## INSPECTION REPORT

**PROJECT NAME:** Ellison St. Office Warehouse

**LOCATION:** 4000 Ellison St. NE, Albuquerque, New Mexico, 87109

**TRACKING NO:** NMR1004C1, NMR1004CM

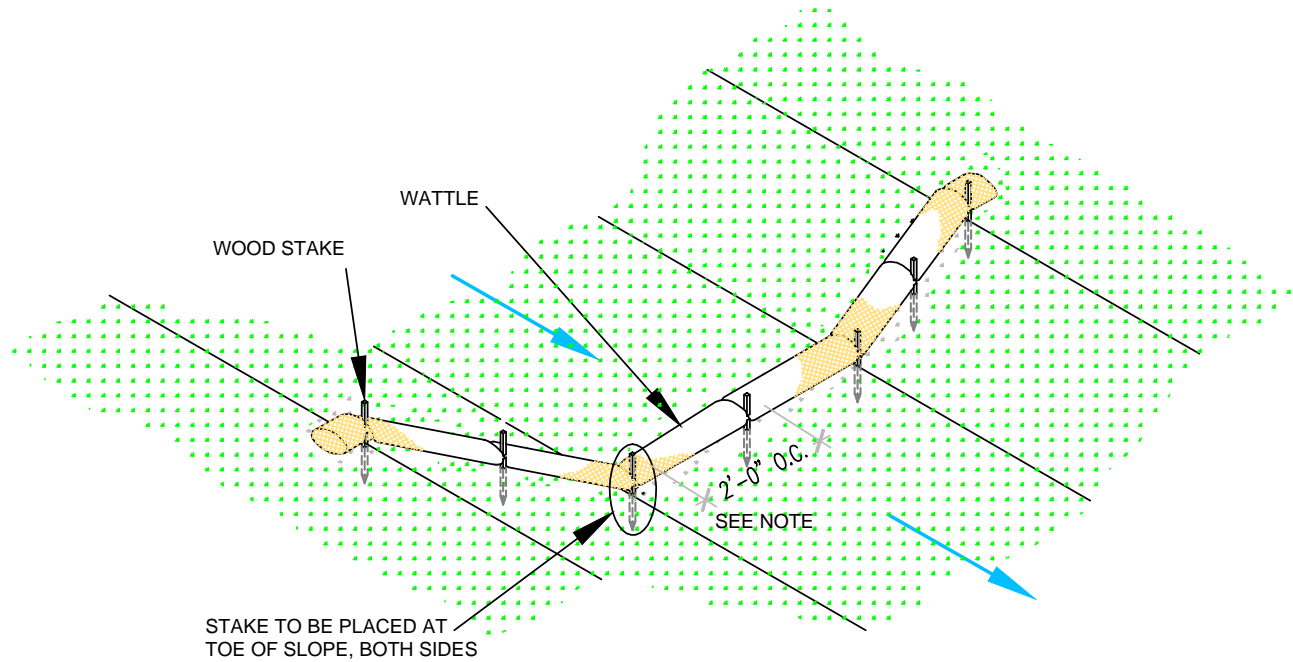
#	S&E/P2 CONTROLS	MAINTENANCE	CORRECTIVE ACTION	LOCATION	QUANTITY	UNIT	PHOTO
1	NPDES Permit Notification	None	Re-install	Entrance	1	EA	<a href="#">Yes</a>
2	Construction Entrance	None	None	Entrance	1	EA	
3	Silt Fence	None	Re-install	Perimeter	1700	LF	<a href="#">Yes</a>

NPDES POSTING BOARD

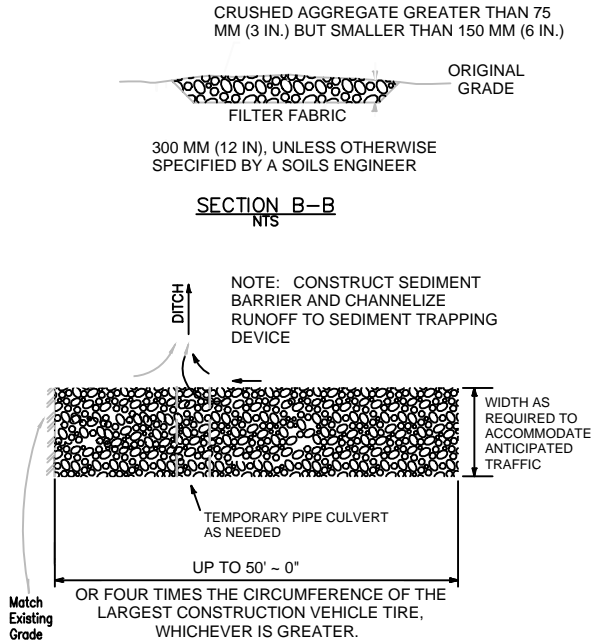
#	INSPECTION ITEM	INSPECTOR'S OBSERVATION	ACTION REQUIRED?	NOTES
1	Is the SWPPP signage clearly posted with the correct information and properly displayed at an obvious perimeter location?	<input type="radio"/> Yes <input checked="" type="radio"/> No <input type="radio"/> N/A	<input checked="" type="radio"/> Yes <input type="radio"/> No	Need to have a posting board installed
2	Are steep slope areas not actively being worked properly stabilized?	<input type="radio"/> Yes <input type="radio"/> No <input checked="" type="radio"/> N/A	<input type="radio"/> Yes <input checked="" type="radio"/> No	
3	Are disturbed areas not actively being worked properly stabilized?	<input type="radio"/> Yes <input checked="" type="radio"/> No <input type="radio"/> N/A	<input checked="" type="radio"/> Yes <input type="radio"/> No	Site needs to do soil stabilization since it been inactive
4	Are natural resource areas (e.g. streams, wetlands, mature trees, etc.) protected with barriers or similar BMPs?	<input checked="" type="radio"/> Yes <input type="radio"/> No <input type="radio"/> N/A	<input type="radio"/> Yes <input checked="" type="radio"/> No
